RE: Further response to submissions – Wetherill Park Resource Recovery Facility SSD7267

Please find below SUEZ' response to further submissions from the following agencies regarding the Wetherill Park Resource Recovery Facility (WPRRF) SSD7267:

01 SITE PLAN

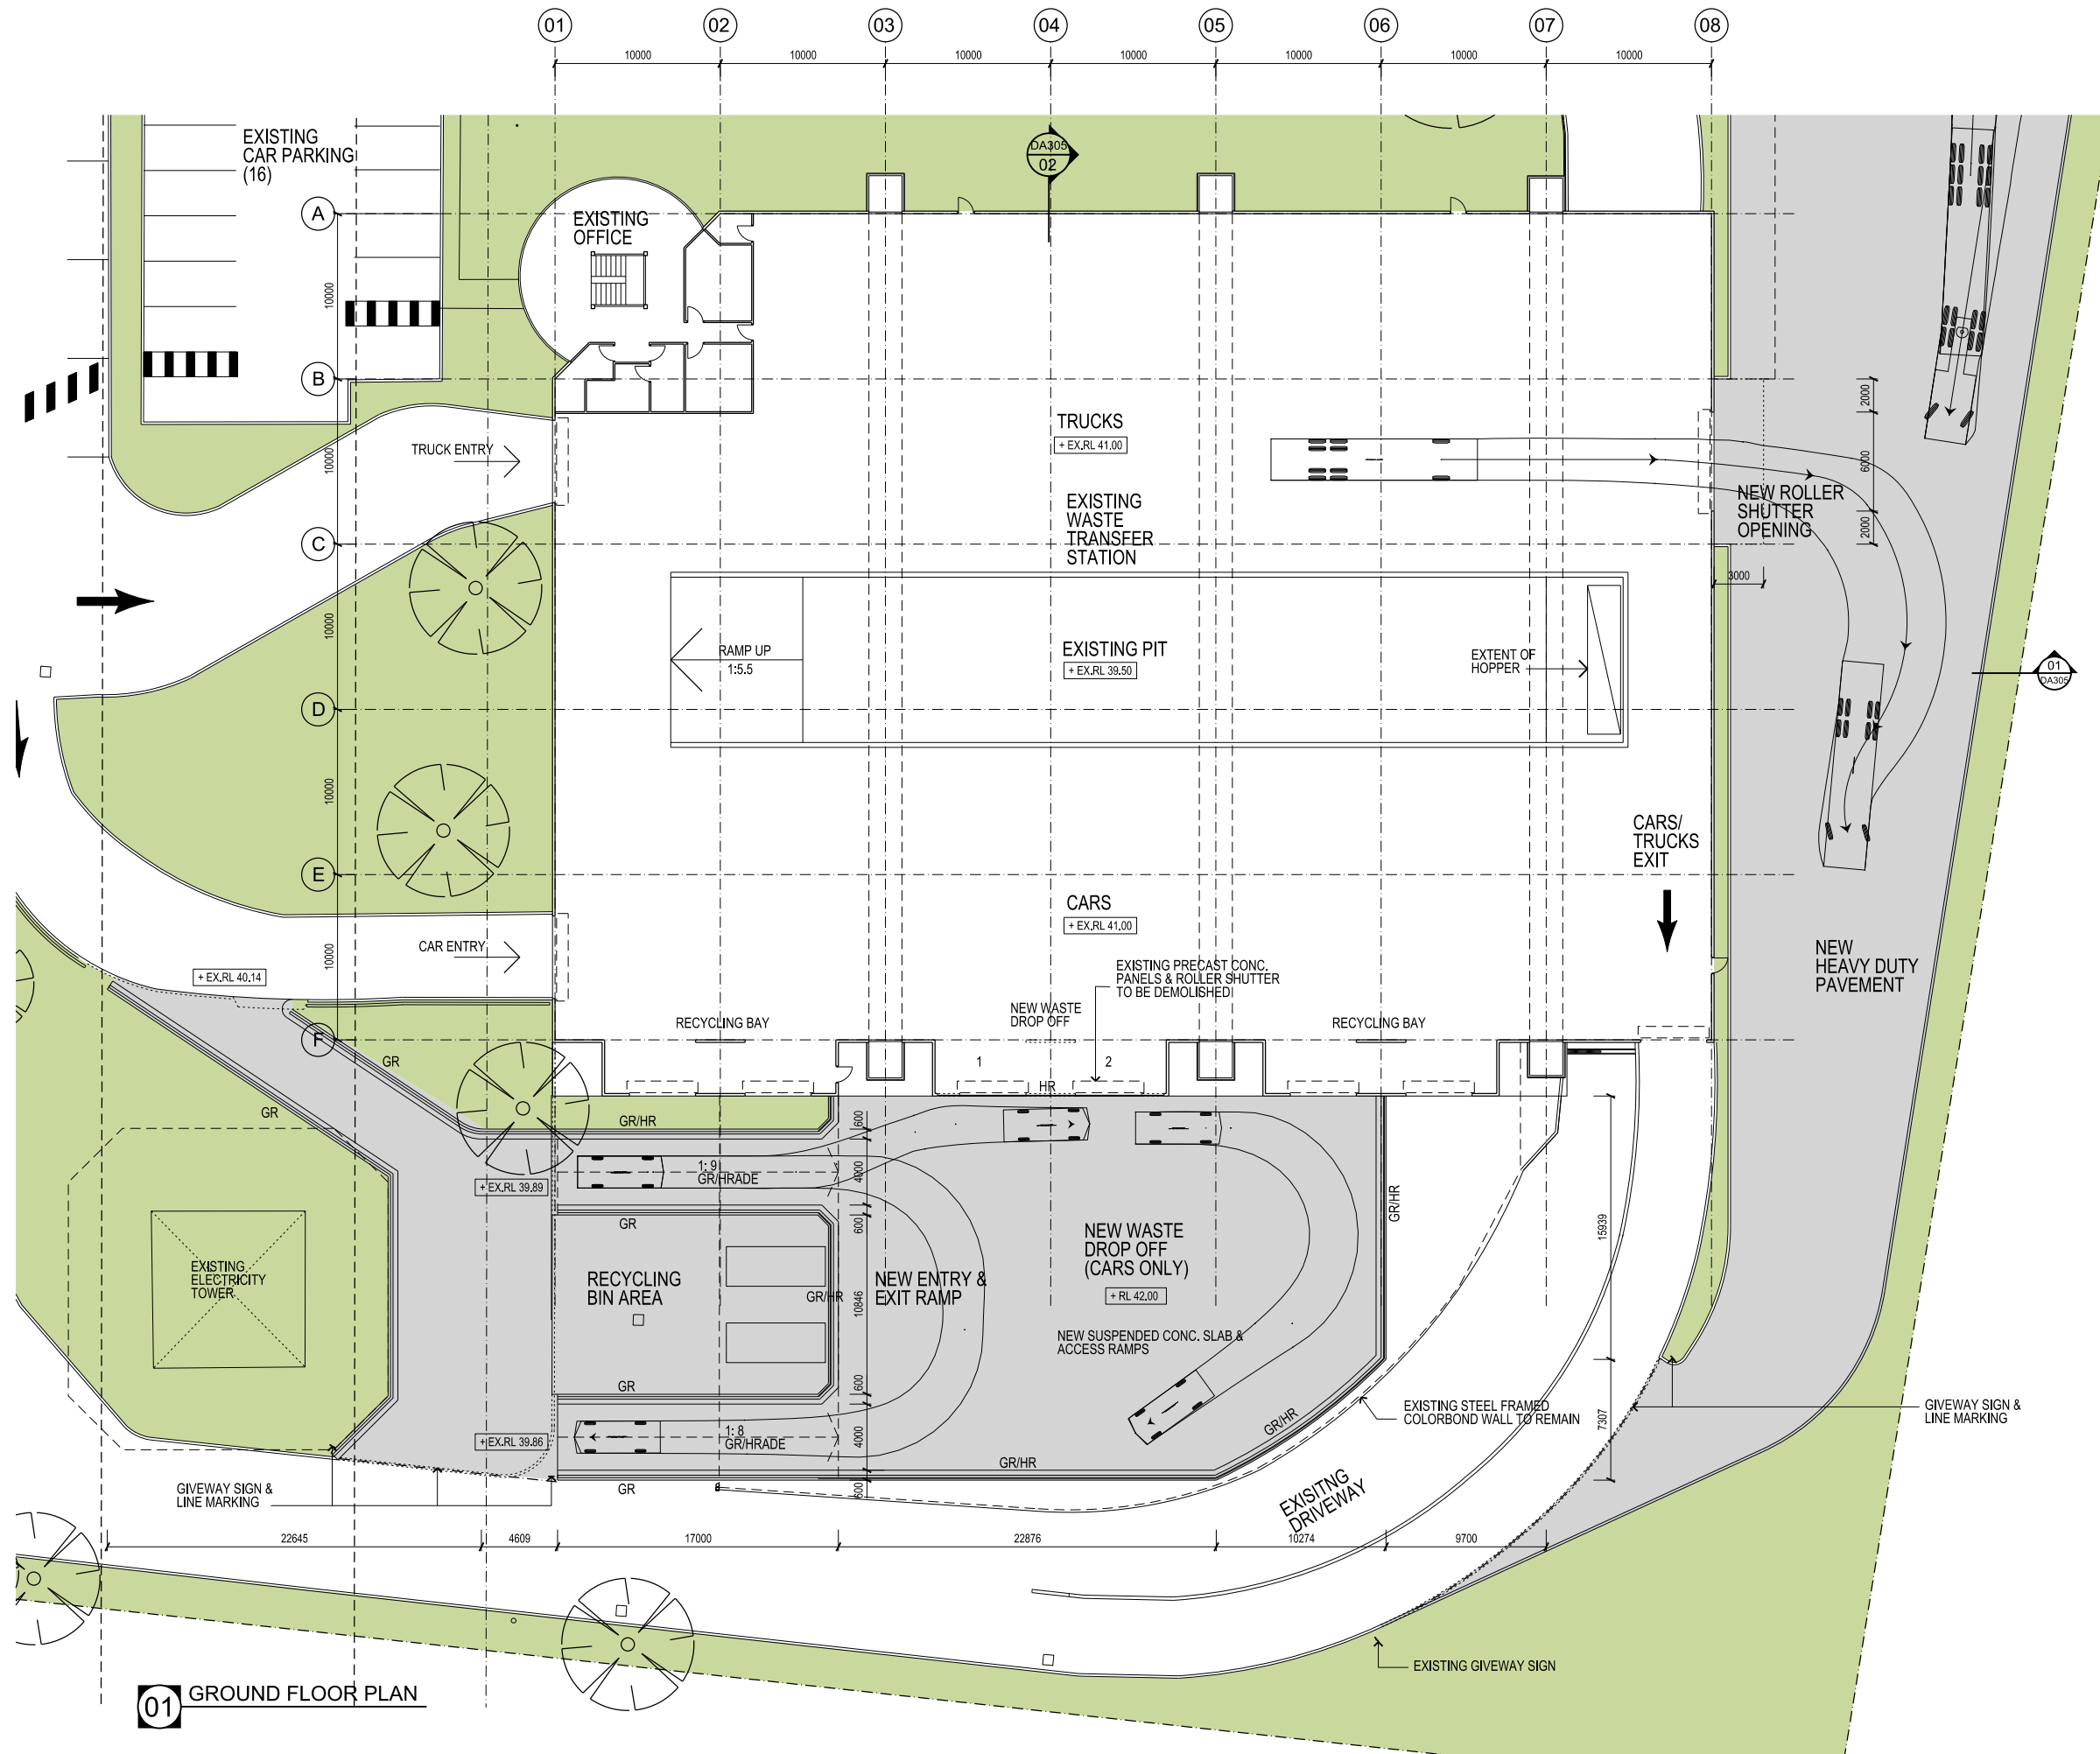
The EPA has reviewed the Response to Submissions and is generally satisfied with the information provided, however has identified that odour emissions from the proposed truck trailer area east of the transfer station building were not sampled in the Environmental Impact Statement nor were any mitigation measures provided to address potential fugitive odours from this area.

Trailers used for transport of putrescible waste parked in the proposed area are likely to be a source of odour particularly if the trailers are open/walk in floor style. Unless transfer trailers are parked within an enclosed building, are free of waste residue or are sufficiently airtight with a continuous rubber seal then they should have been included in odour modelling for the premises.

After reviewing the results, Council's Catchment Branch is satisfied that the impact to flood levels will be kept within the proponents site and complies the Flood Effects section of Schedule 6 of Chapter 11 of the DCP. It is noted that the driveways at the rear of the property have over 1m depth of floodwater in the 100 year ARI, and these areas should be not be used as an evacuation route during times of flooding.

Regarding the truck parking area, SUEZ agrees that while the trailers are not airtight, the outsides of the trailers are cleaned on a fortnightly basis by a specialist contractor in accordance with the SUEZ Wetherill Park Environmental Management Plan (EMP) which removes any dirt and debris on the outside. In addition, the trucks have covers which reduces the area exposed to only a small portion of the container area. Operationally, the trucks would not be on site for most of the day and would only be parked overnight, with majority of the time being onsite not overlapping with the working hours of adjacent commercial / industrial properties.

Furthermore, the distance between the transfer station and the truck parking area is only approximately 50 metres. The impact of this short term odour source would be covered by the conservatism applied in the latest round of odour modelling which demonstrates significantly less than 2OU at residential properties.

SUEZ notes FCC's comments and would not use the driveway at the rear of the property as evacuation route during times of flooding.
